September 5, 2024

**Re: Martinez Retail Center at 1021 Old Coors Rd SW  
Erosion and Sediment Control Plan  
Engineer's Stamp is not legible (L11E071)**

Principal Engineer, Planning Dept.  
Development and Review Services

CITY OF ALBUQUERQUE DEPARTMENT OF MUNICIPAL DEVELOPMENT ENGINEERING DIVISION	
			MARTINEZ RETAIL CENTER	
			EROSION CONTROL PLAN	
DESIGN REVIEW COMMITTEE		CITY ENGINEER APPROVAL		ZONE MAP NO. L-11-Z
				CITY PROJECT NO. N/A
				SHEET NO. 1 of 2

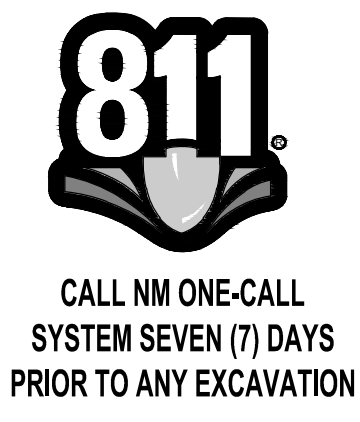
3. The ESC Plan is blurry and hard to read. The engineer's stamp is illegible and missing from some sheets. The sheets are 8.5" x 11", but the required size is 22" x 34". All sheets in the ESC Plan sets must be on a standard-size sheet with a standard border and title block as required by the drafting standards in the city's Development Process Manual (DPM) Part 4-2, and templates are at [https://documents.cabq.gov/planning/DevelopmentReviewServices/DRC/CABQ\\_Title\\_Block.dwg](https://documents.cabq.gov/planning/DevelopmentReviewServices/DRC/CABQ_Title_Block.dwg). Each ESC Plan sheet should have an ESC Plan title block that identifies the sheet number and the total number of sheets in the ESC Plan, for example, "Sheet 1 of 3."

5. A legend showing the limits of disturbance and BMPs is missing and is required by the drafting standards and must be shown on the ESC Plan.
6. The Limits of Land-Disturbing Activities are missing from the ESC Plan. You must accurately identify the location of limits of disturbance on the ESC Plan. Be sure to include any offsite construction support activities in the limits.

7. Identify the post-construction stormwater quality ponds as temporary sediment traps to be constructed with the rest of the stormwater controls (BMPs) as the first items of construction.

8. Describe the nature and extent of construction activities (CGP 7.2.2.). Include the size of the property and the size of the area of land-disturbing activities onsite and offsite. Describe construction support activities and show the staging area on the ESC Plan. Describe the construction sequence, with the placement and removal of the required stormwater controls being the first and last items of construction.

SHEET NO.
2 of 2

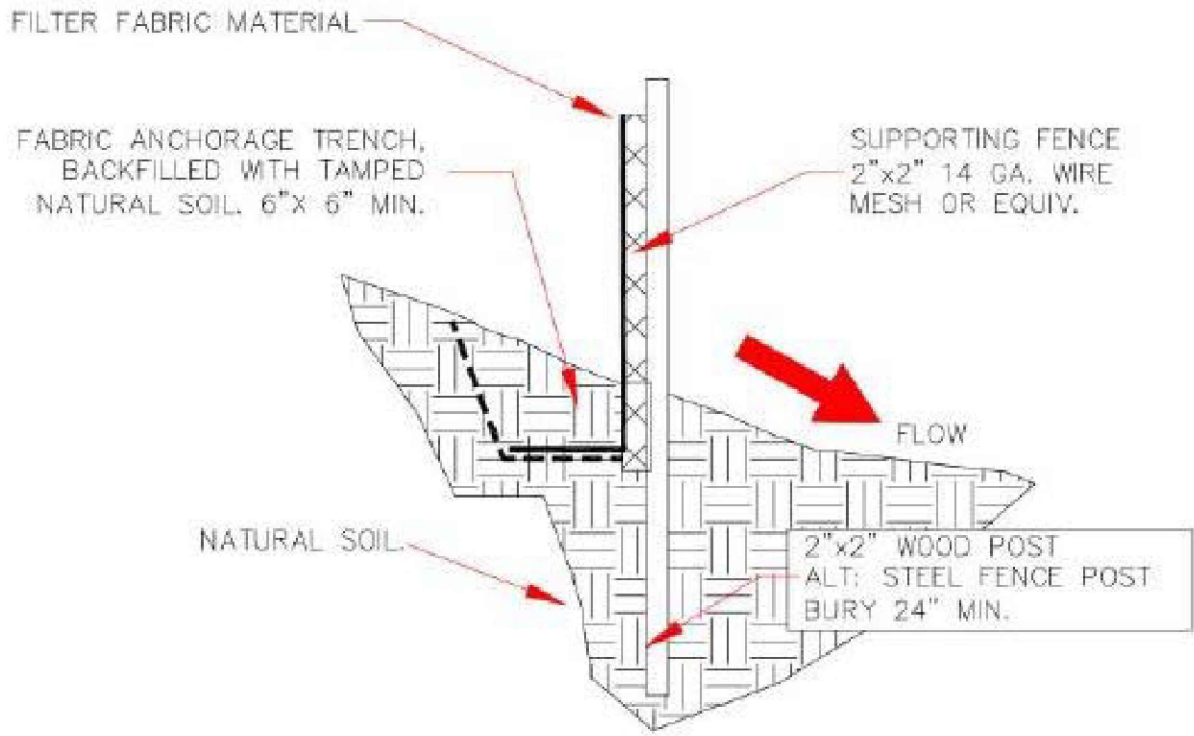
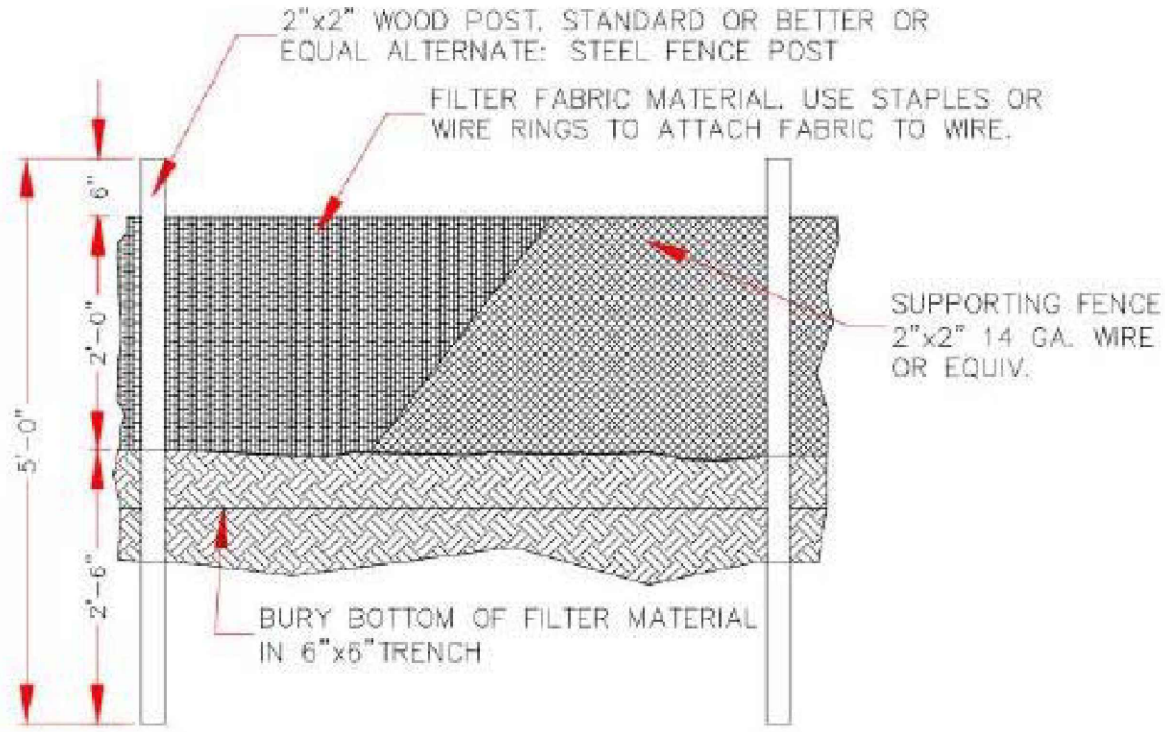
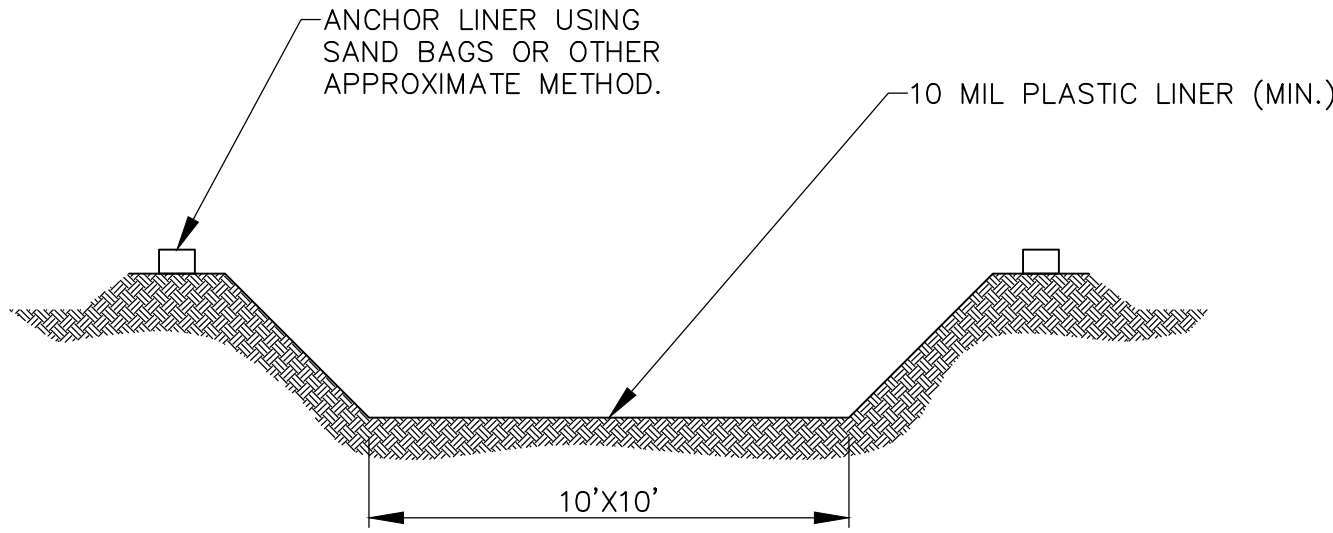
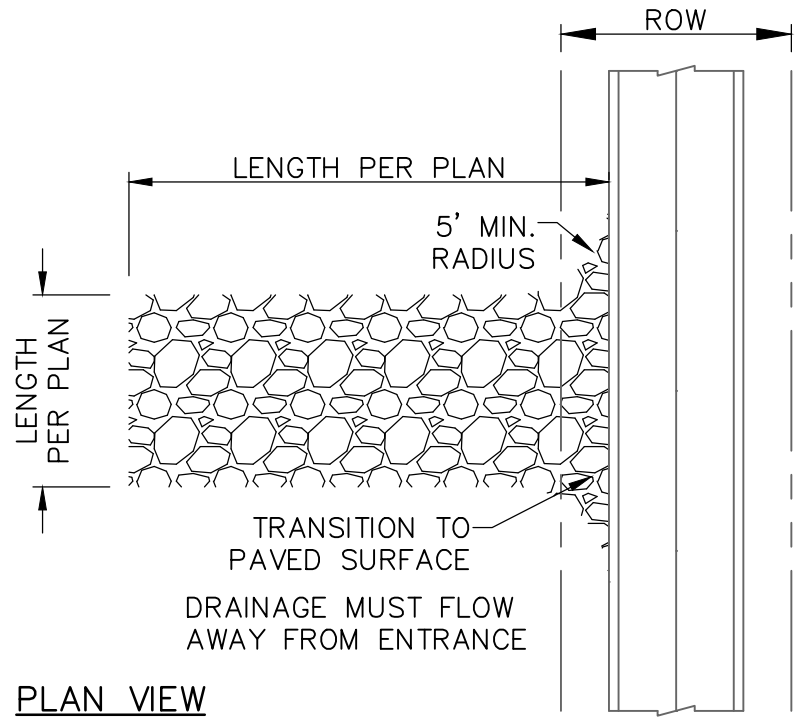
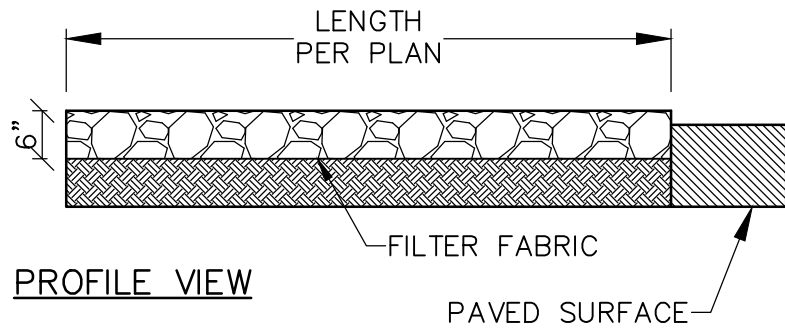
4. Construction details and specifications are missing from the ESC Plan for most of the stormwater controls, including but not limited to the construction exit, washout, and waste containers.

SHEET NO: C-1

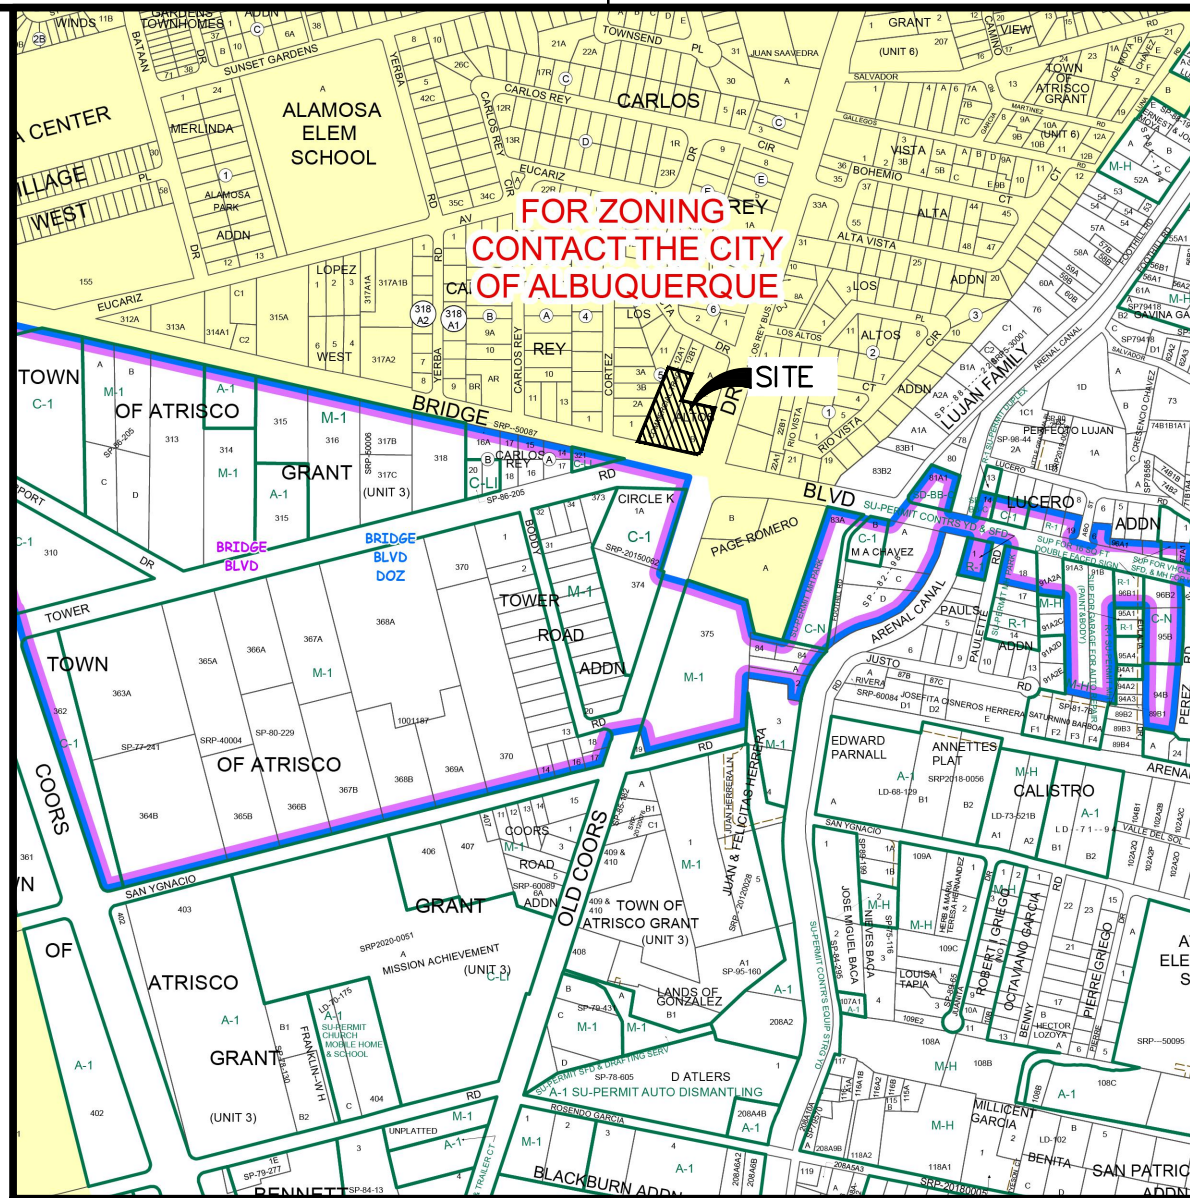
10. The Engineer's stamp wasn't updated after the Erosion Controls were added to the Grading and Drainage Plan, and some of the sheets were not stamped and signed. Update the engineer's stamp & date on all sheets each time the plan changes.

LANDSCAPE PLAN

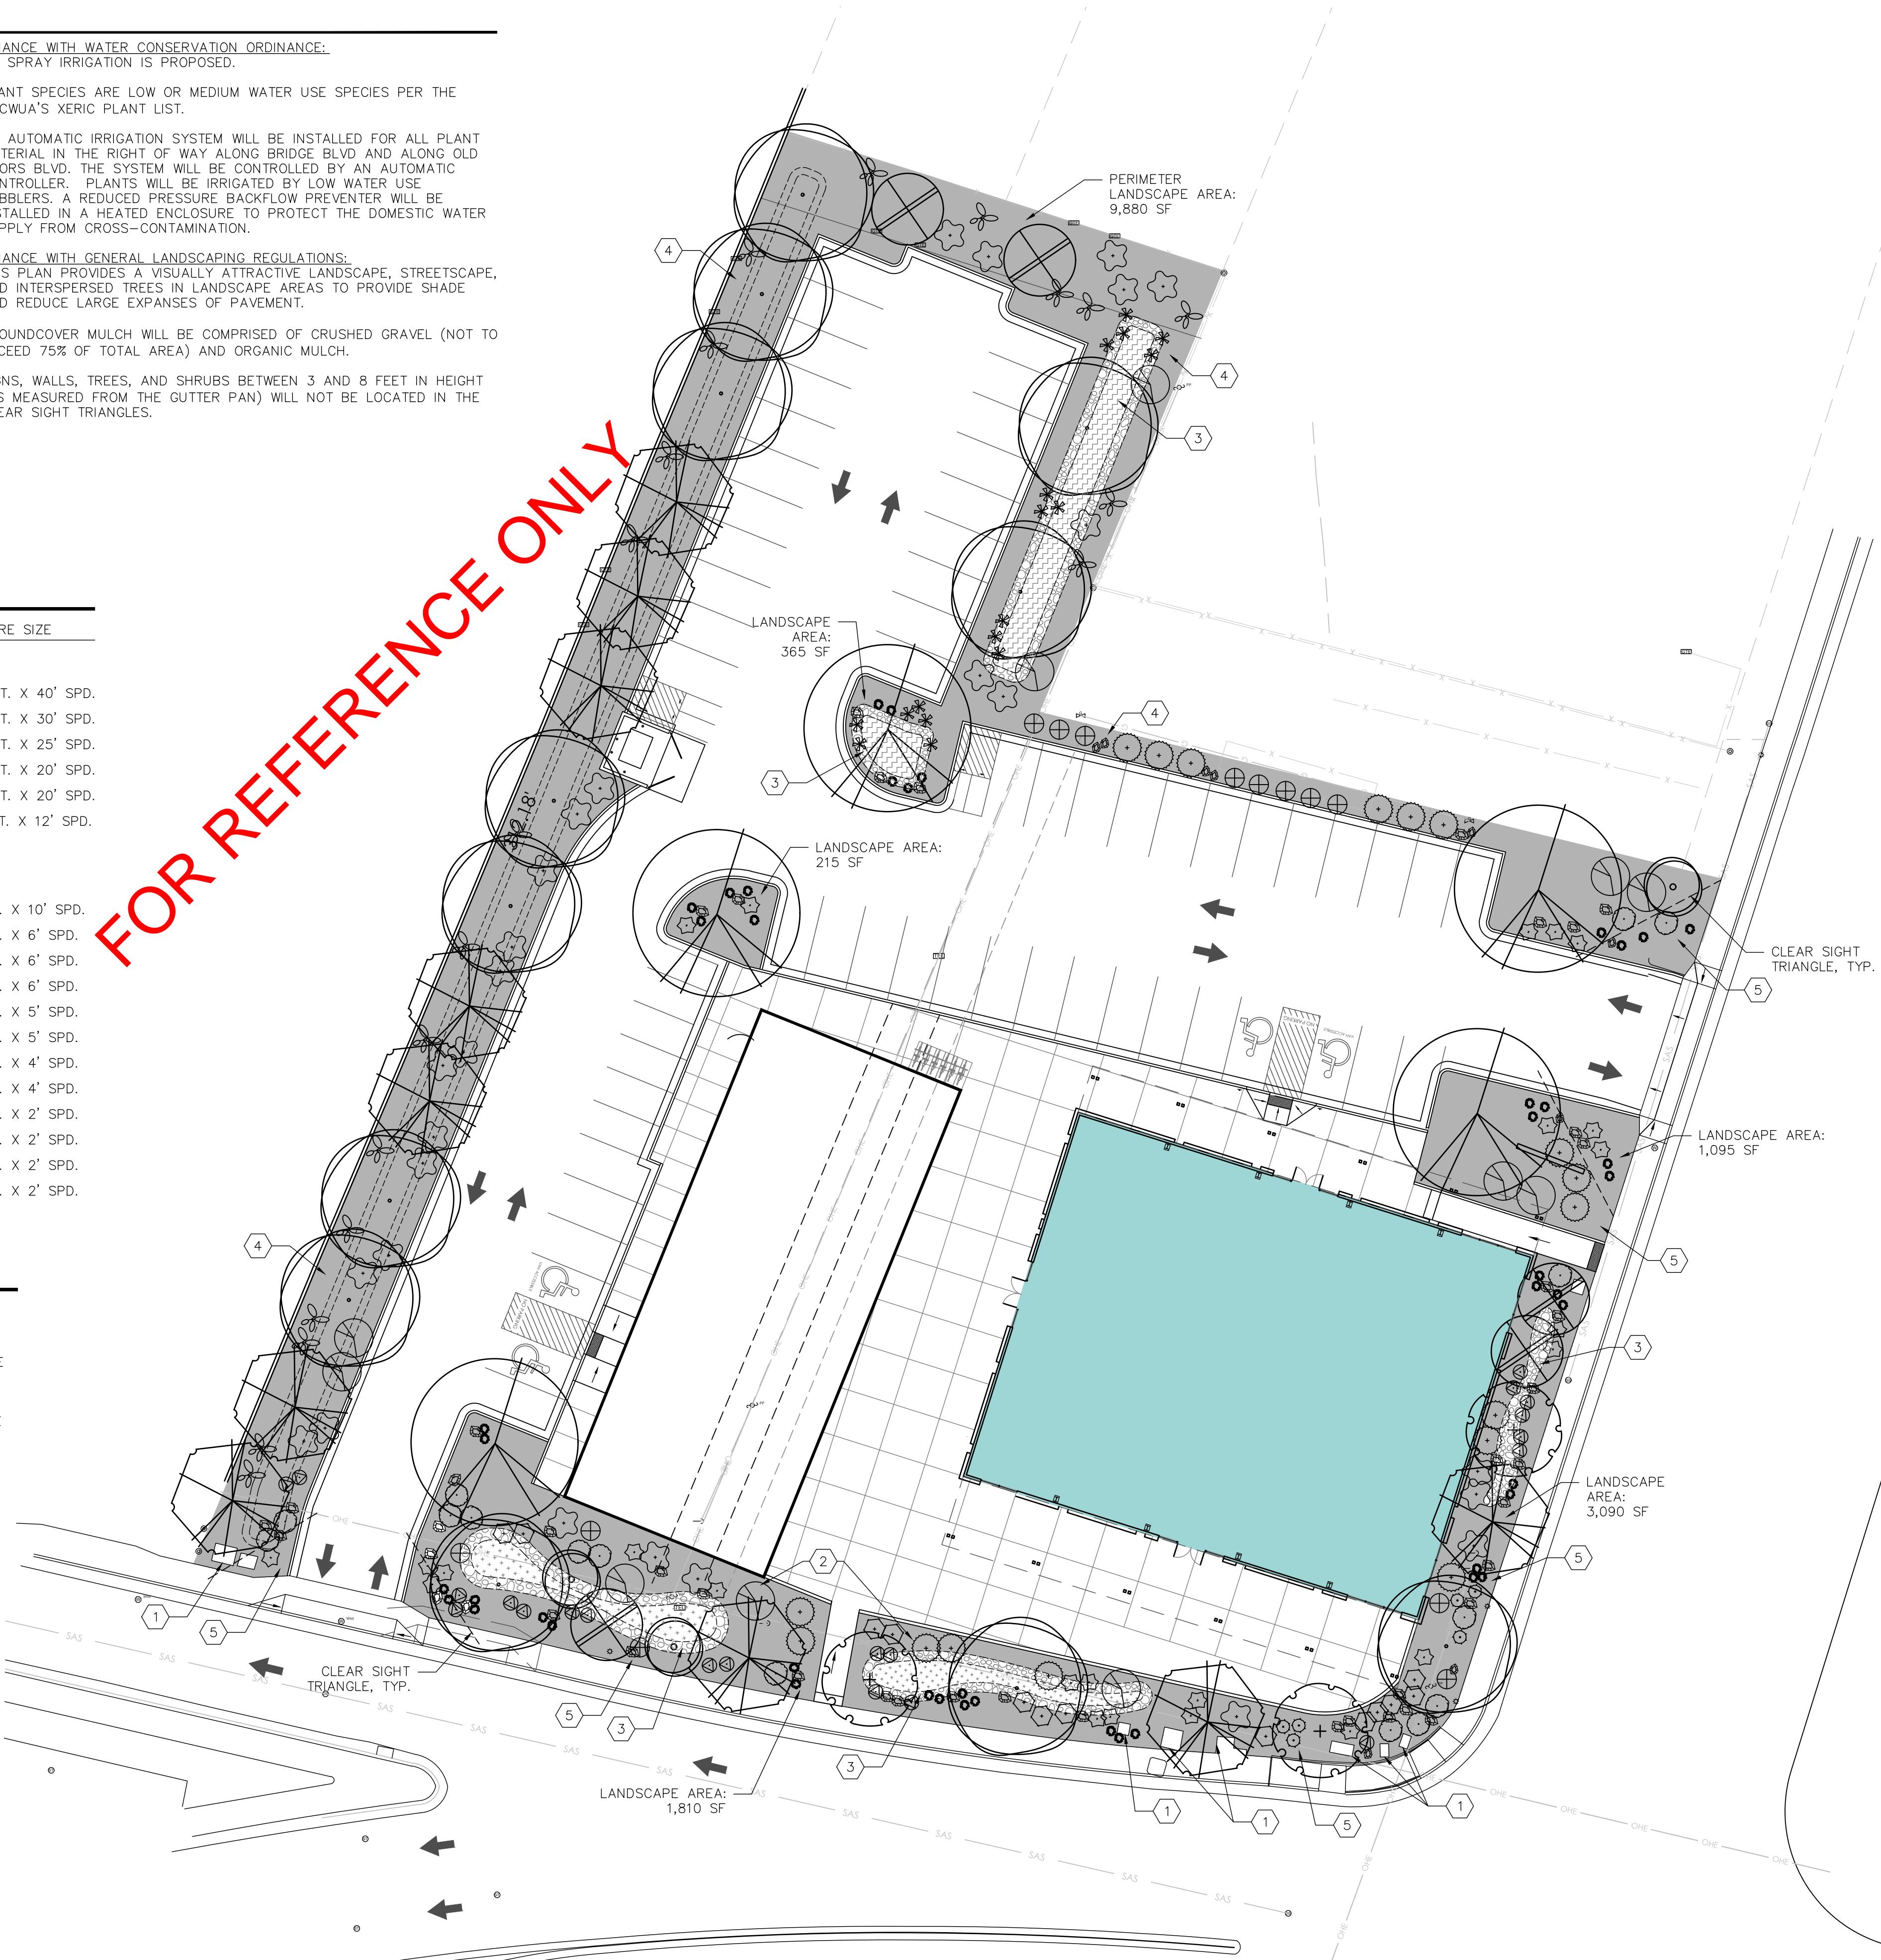
9. The SWPPP must include site-specific interim and permanent stabilization per CGP 9.6.1.c.i. The Landscape Plan can satisfy this requirement. It should be stamped and signed by a registered professional landscape architect, submitted separately from the ESC Plan with the application to the Stormwater Quality Section of the Planning Department, and included in the SWPPP. Provide specifications on the ESC Plan for any disturbed areas not covered by the Landscape Plan.
